Application no: **3/2023/0054**

Address: **Bomber Farm Skipton Road Gisburn BB7 4HP**

Proposal: **Conversion of barn to one dwelling and retention of replacement agricultural building (Part retrospective).**

6597 -P03	REV -
------------------	----------

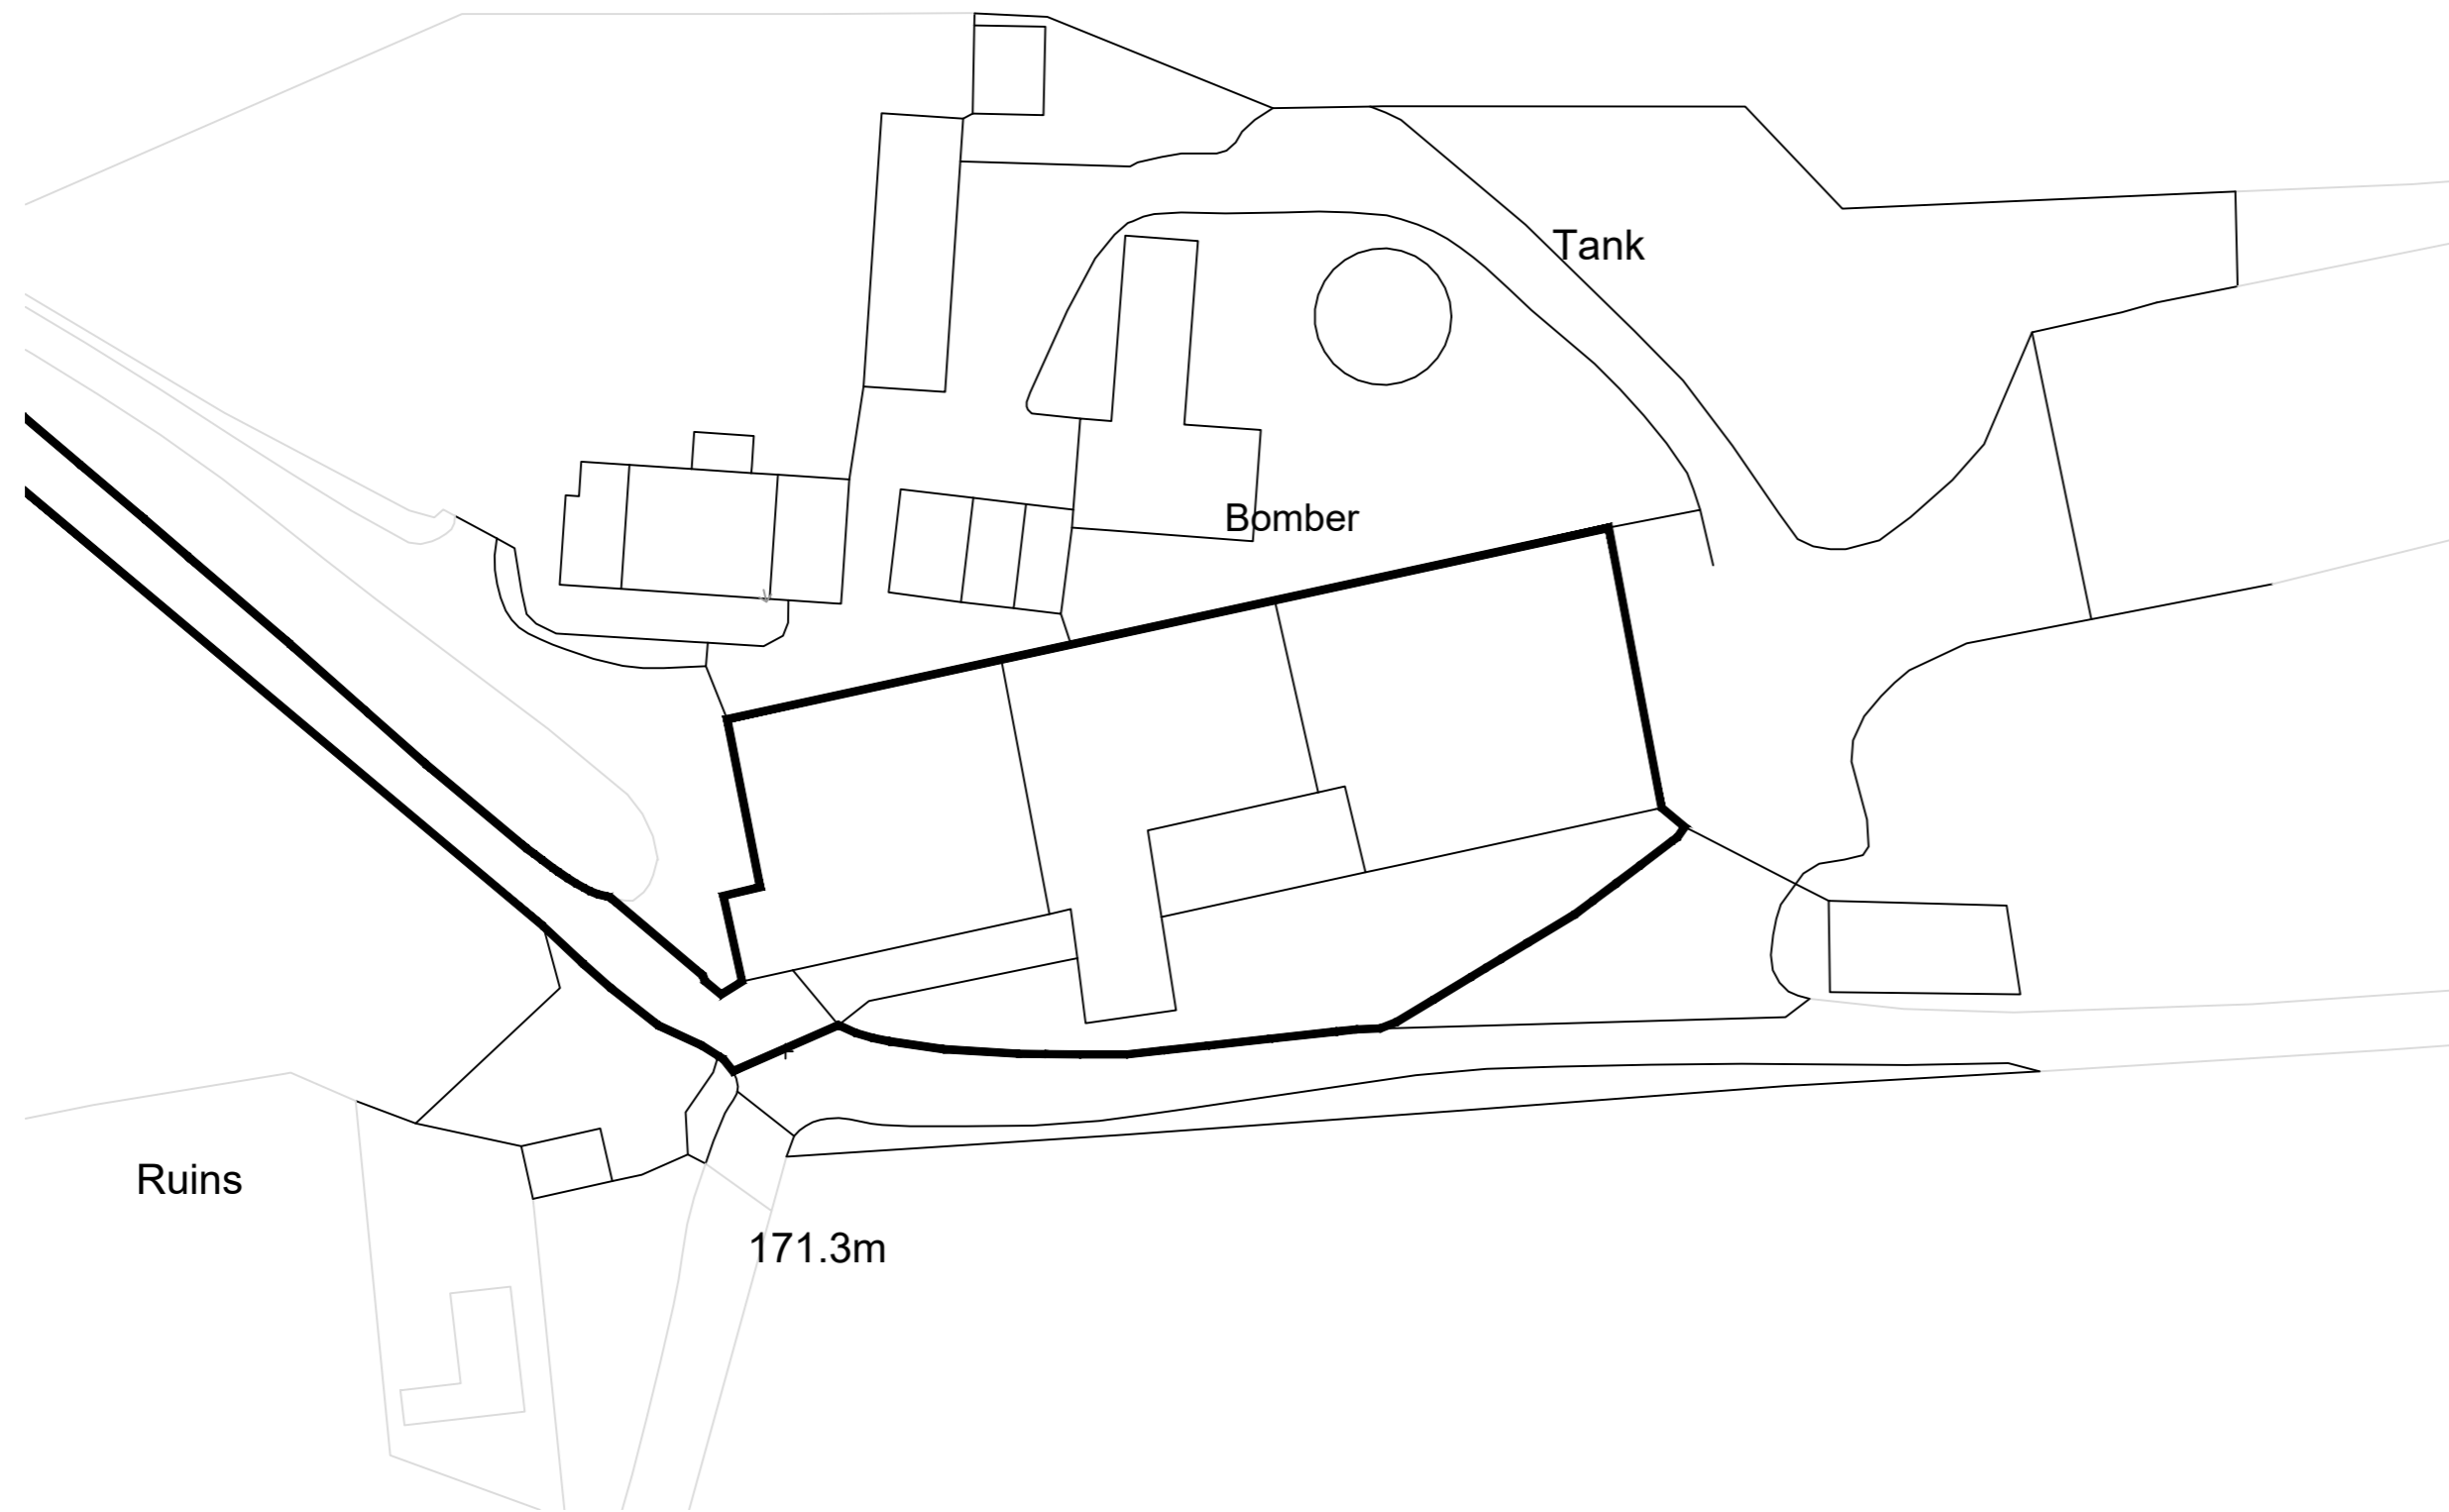
The LHA have reviewed SPA drawing number 6597-P02 Rev A titled "Proposed Site Plan" and are aware that 2 car parking spaces for the 4-bed dwelling will be provided at the site. This does not comply with the LHAs parking guidance as defined in the Joint Lancashire Structure Plan, which requires the site to provide 3 car parking spaces.

Despite this, the LHA will accept the shortfall in the parking with there being ample space on site to provide the additional car parking space if required.

It is worth noting that the LHA will condition that a minimum of one car parking space located within the double garage has access to an electric vehicle charging point and that the cycle store located adjacent to the garage is kept free of obstructions and available for the parking of cycles at all times.

1. The development hereby permitted shall not be occupied until such time as the parking and turning facilities have been implemented in accordance with SPA drawing number 6597-P02 Rev A. Thereafter the onsite parking provision shall be so maintained in perpetuity.

2. The garage facility shall include provision of an electrical supply suitable for charging an electric motor vehicle.

3. No building or use hereby permitted shall be occupied or the use commenced until the cycle parking provision shown on the approved plans has been completed. The area shall thereafter be kept free of obstruction and available for the parking of cycles only at all times.
